CITY OF ALBUQUERQUE

**Re: Montecito West Units 1 and 2
Erosion Sediment Control (ESC) Plan
Engineer's Stamp Date 1-06-14 (D09/E004)**

MONTECITO WEST UNITS 1 & 2
EROSION CONTROL PLAN

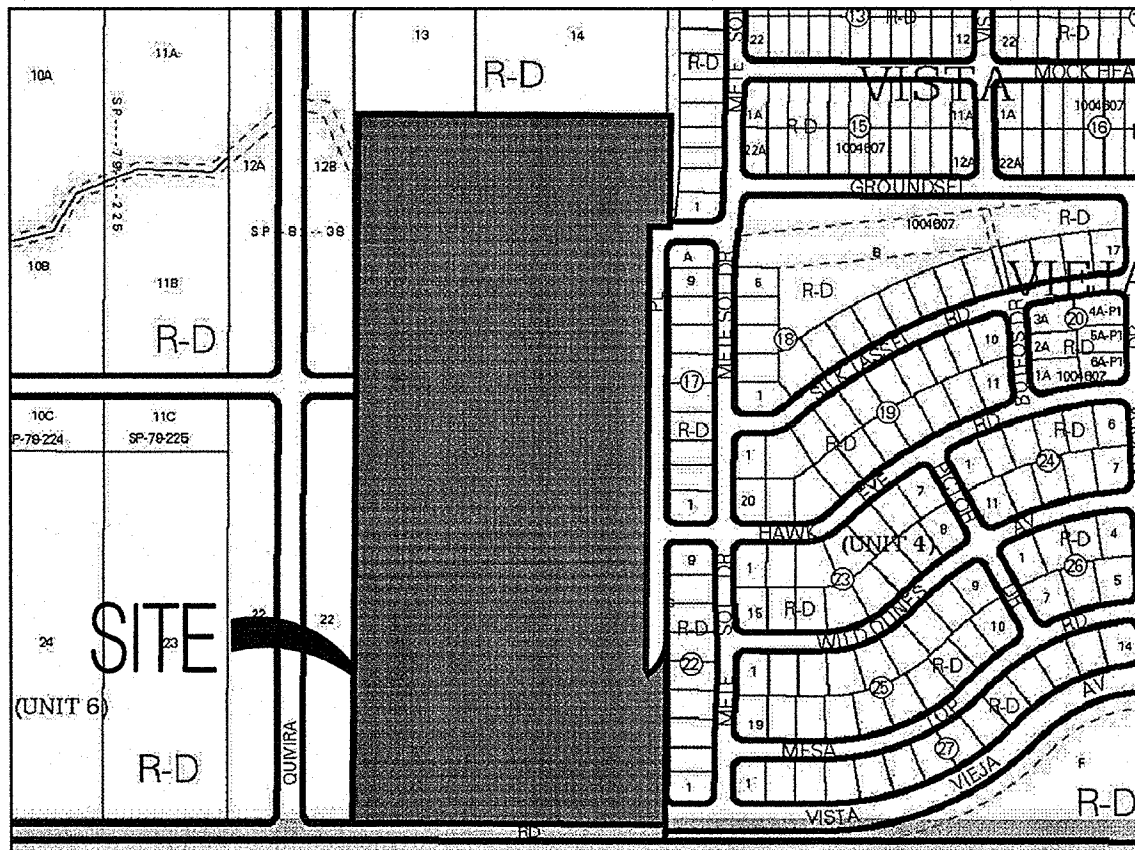
- Grading and Drainage Plan must be approved for Grading and Work Order prior to approval of the ESC plan. Please update your ESC plan based on the final changes to the grading plan.
